BCA ASSESSMENT REPORT

**Oakdale West
Horsley Park**

Client: Goodman Property Services

Date: 29.03.2016

Figure 8-1: Perimeter Access Non-Compliances

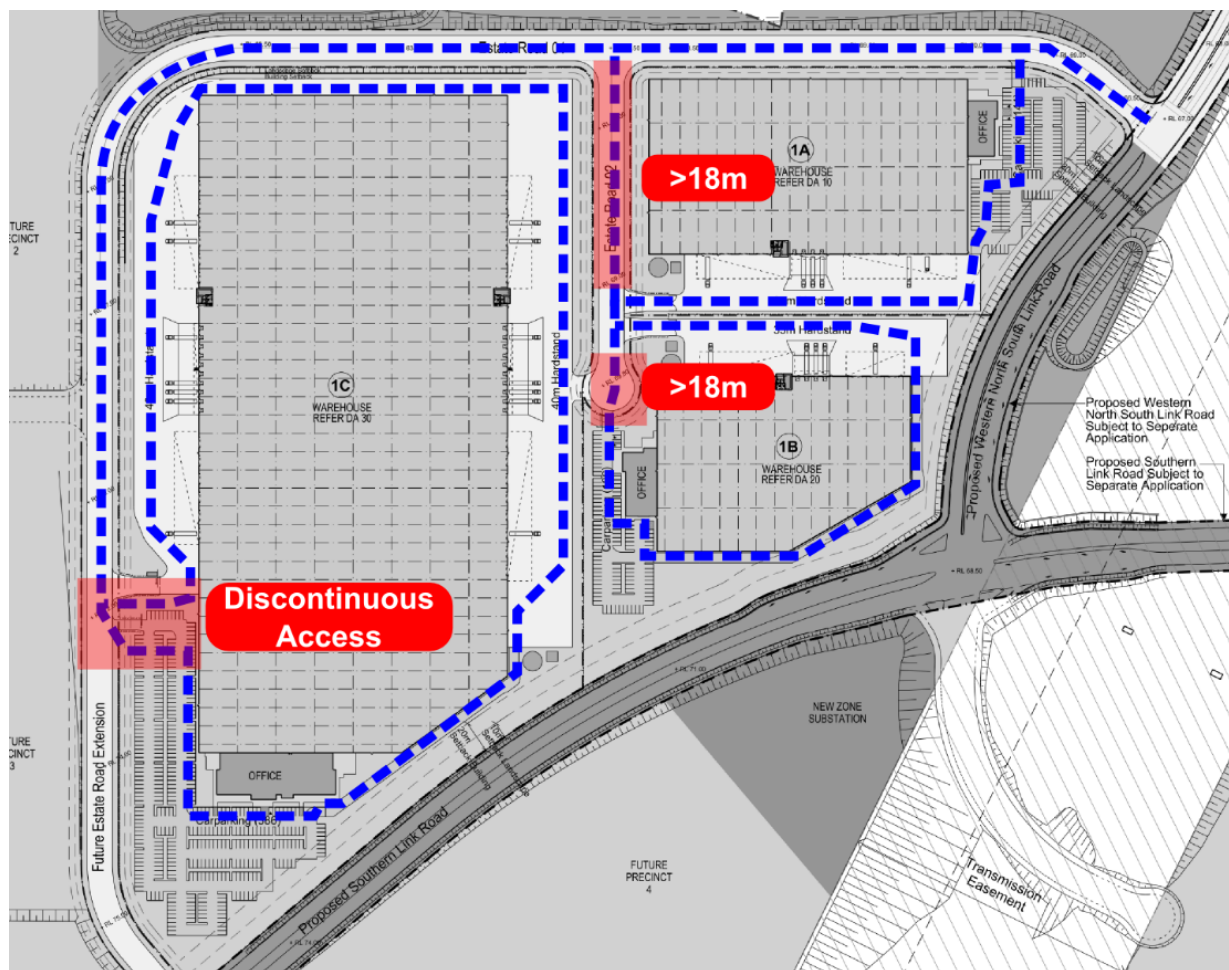
Comments: The proposed warehouse buildings do not comply with the provisions of C2.4 and thus the following non-compliance issues are required to be addressed as an alternative solution by the Fire Safety Engineer to demonstrate compliance with Performance Requirement CP9 - refer to the dot points and the diagram below for details of the proposed non-compliance issues:

- Vehicular Access is provided around the four (4) sides of all of the Warehouses however, it is greater than 18m from the external walls of Buildings 1A & 1B- refer to diagram below.
- Vehicular Access is discontinuous in the SW corner of Building 1C - refer to diagram below.
